# Drainage Report

17115 GOSHAWK ROAD  
COLORADO SPRINGS, CO 80908  
EL PASO COUNTY

January 17, 2019

Engineering Documents  
Reviewed By:  
*Daniel Torres*  
*danieltorres@elpasoco.com*  
EPC Planning & Community  
Development Department

ENG:	RDJ	
DRAWN:	RDJ	
CHECKED:	RDJ	
DATE	04/05/19	
#	REVISION	DATE
	SUBD APP	01/14/19
	SUBD APP 2	01/17/19
	CNTY REV. 1	04/05/19
JOB NO.	167392	
SHEET NO.	EXHIBIT 05

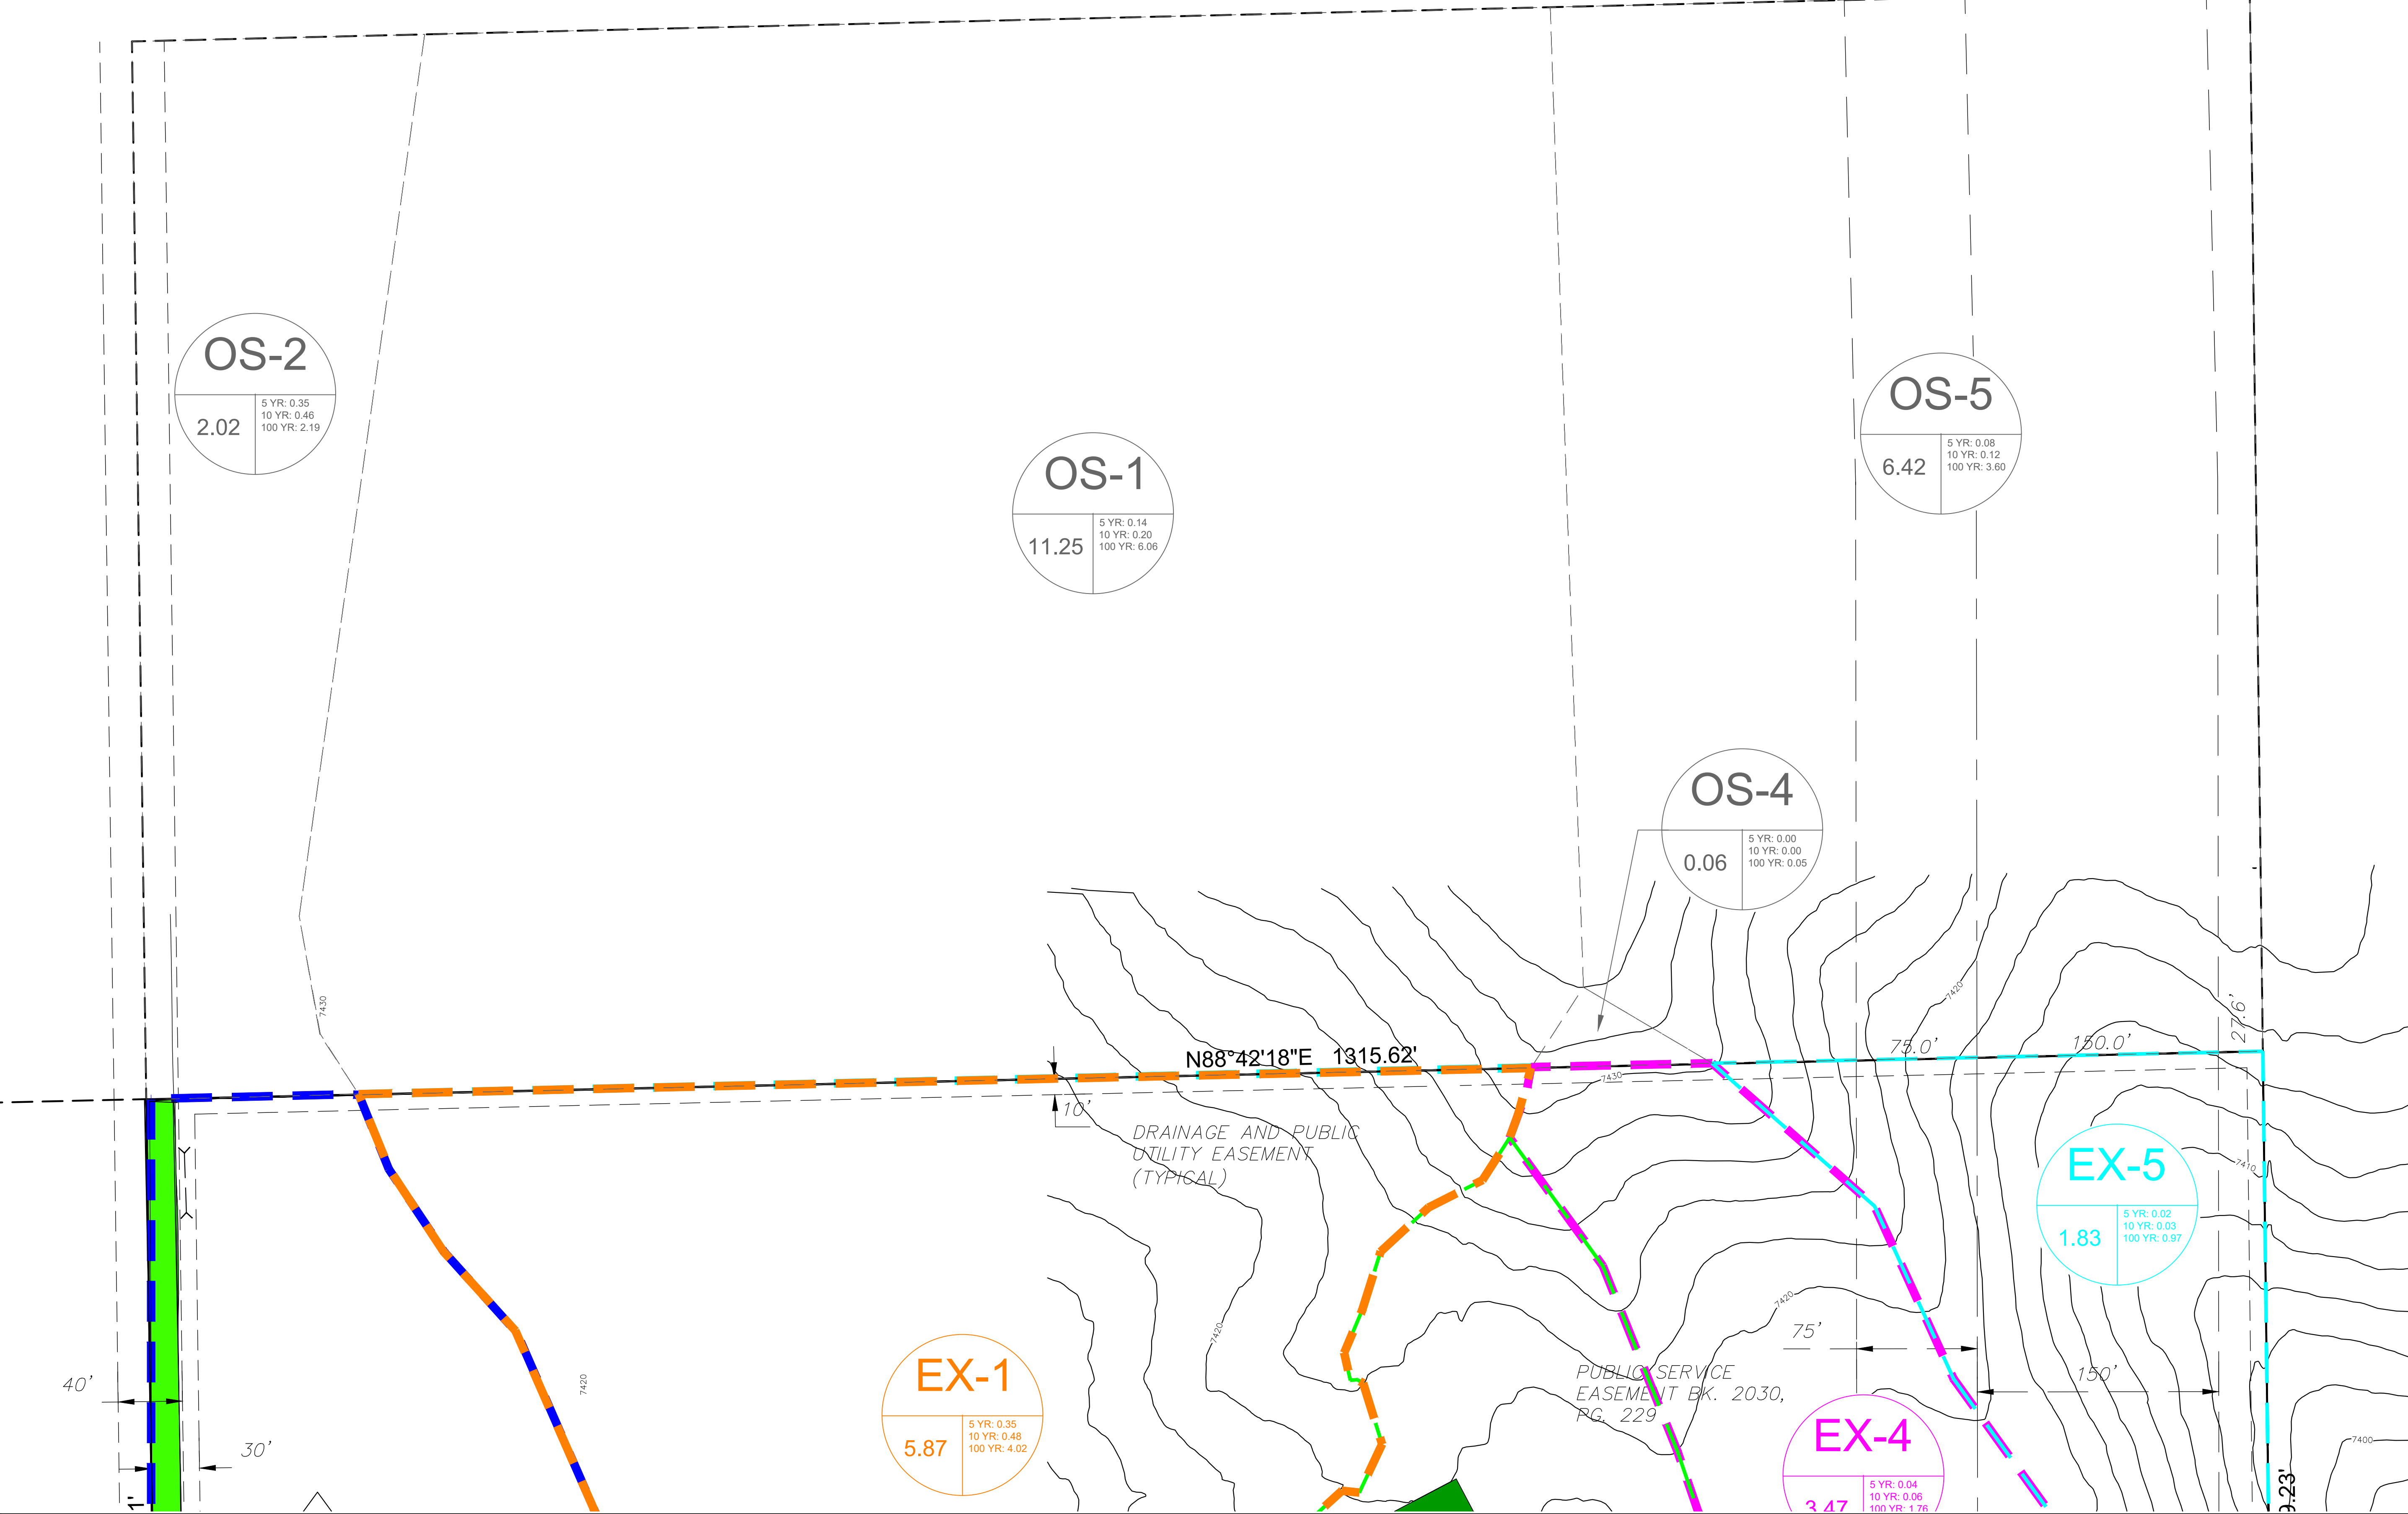
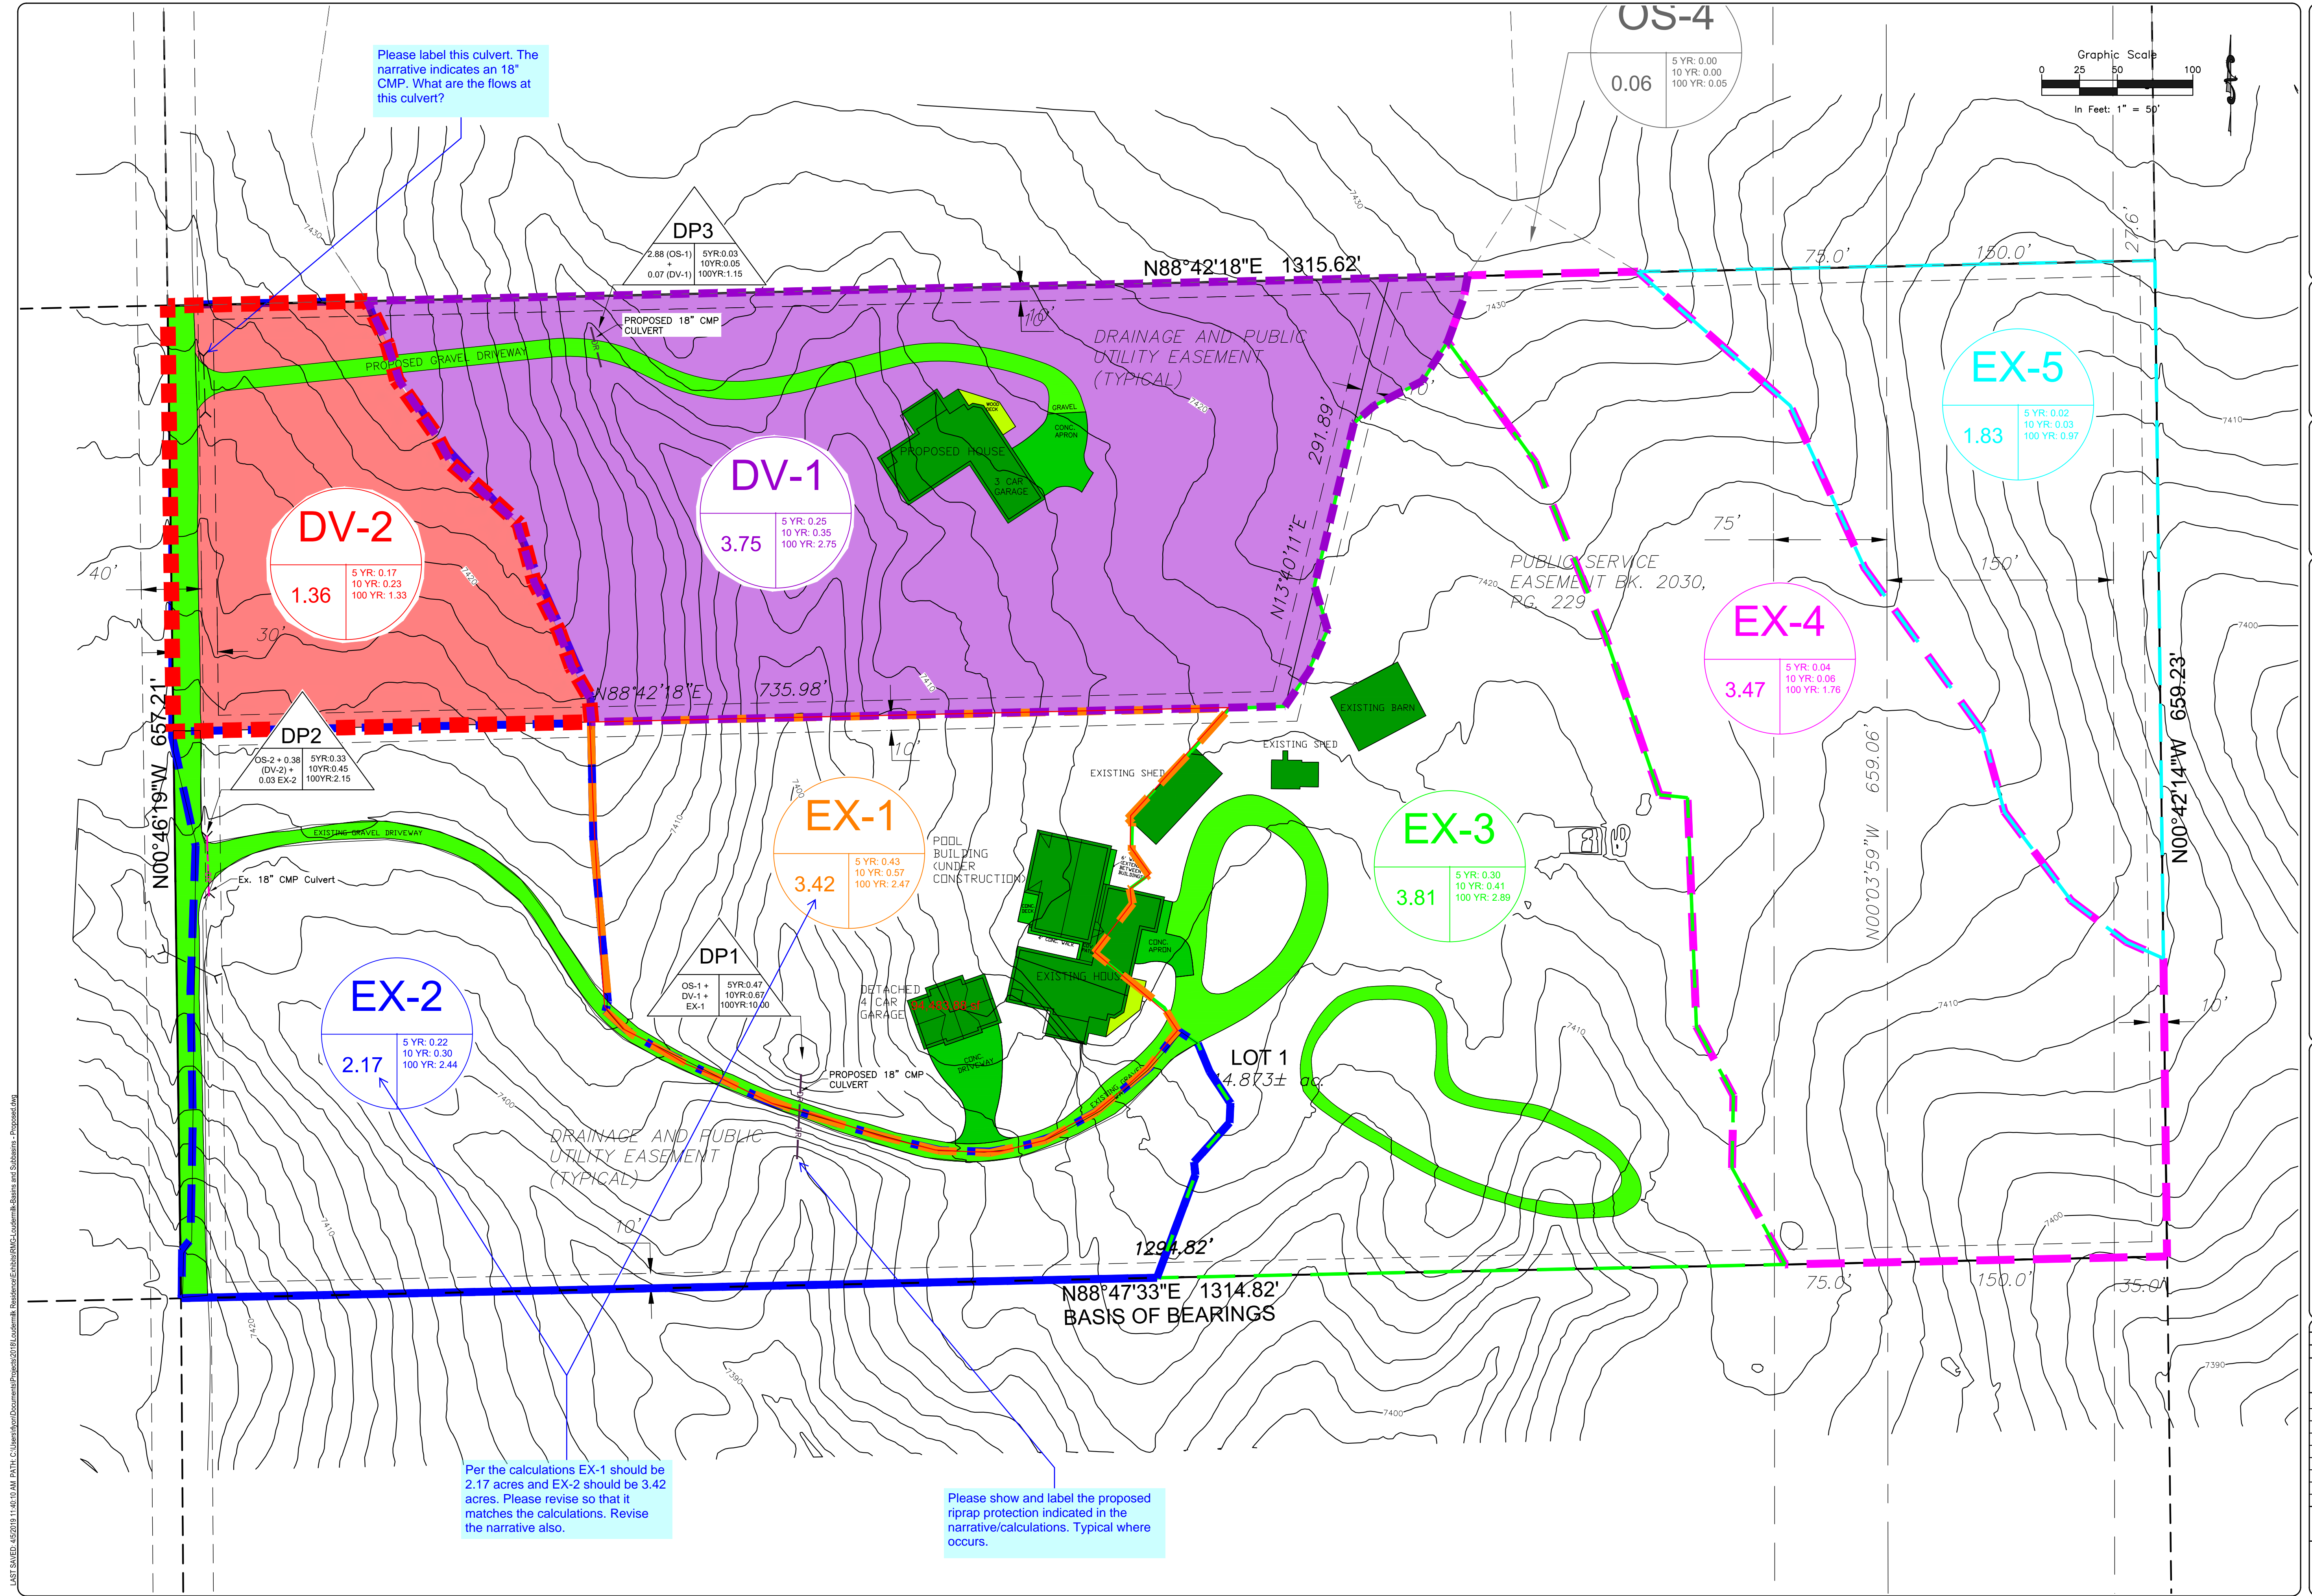
Please indicate the size and type of all culverts and identify them on the drainage plan.

Please indicate the size and type on the drainage plan
